From: Sarah Burrow <Sarah.Burrow@arun.gov.uk>
Sent: 01 July 2021 14:00
To: Planning.Responses <Planning.Responses@arun.gov.uk>
Cc: Simon Davis <Simon.Davis@arun.gov.uk>
Subject: RE: Planning Consultation on: BR/129/21/OUT

Engineers Comments Regarding Surface Water Drainage

Application No: BR/129/21/OUT

Site Address: 26 Burnham Avenue Bognor Regis PO21 2JU

SITE PLAN (PROPOSED) 1:200

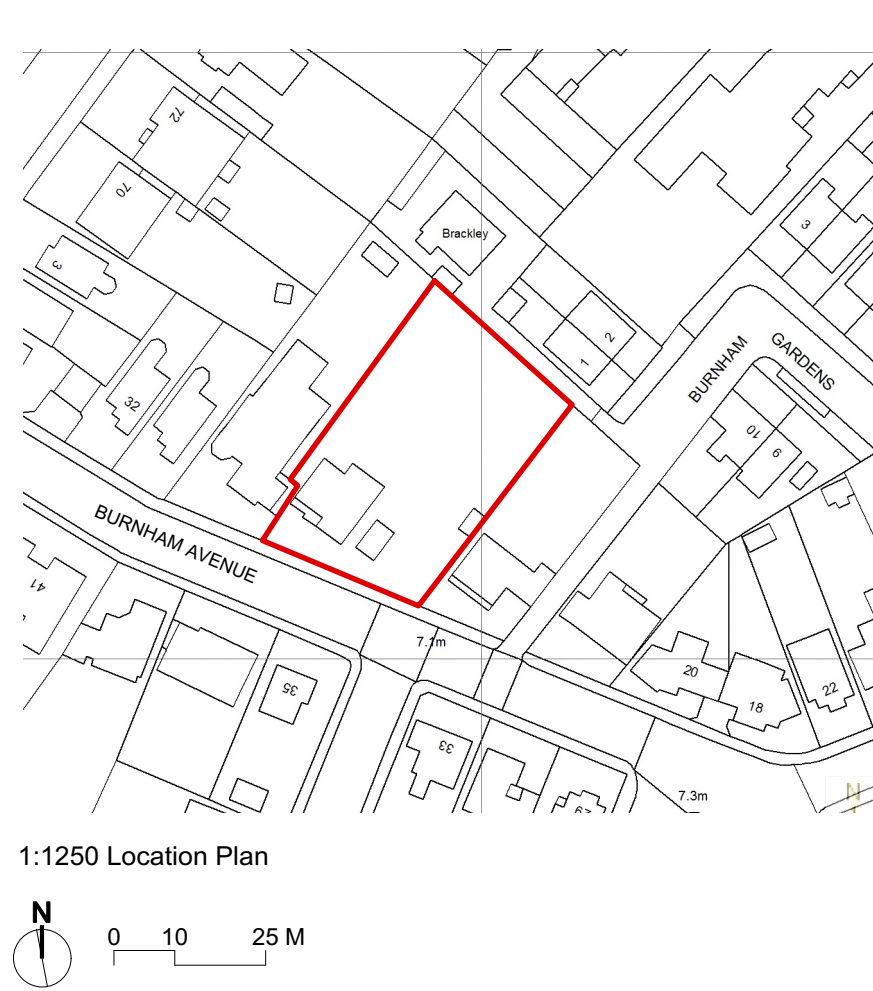
Groundwater levels are expected to be reasonably high. We would expect to see permeable paving to be incorporated for not only the car parking areas but the driveway also, not only to provide a water storage/infiltration structure but to aid water treatment.
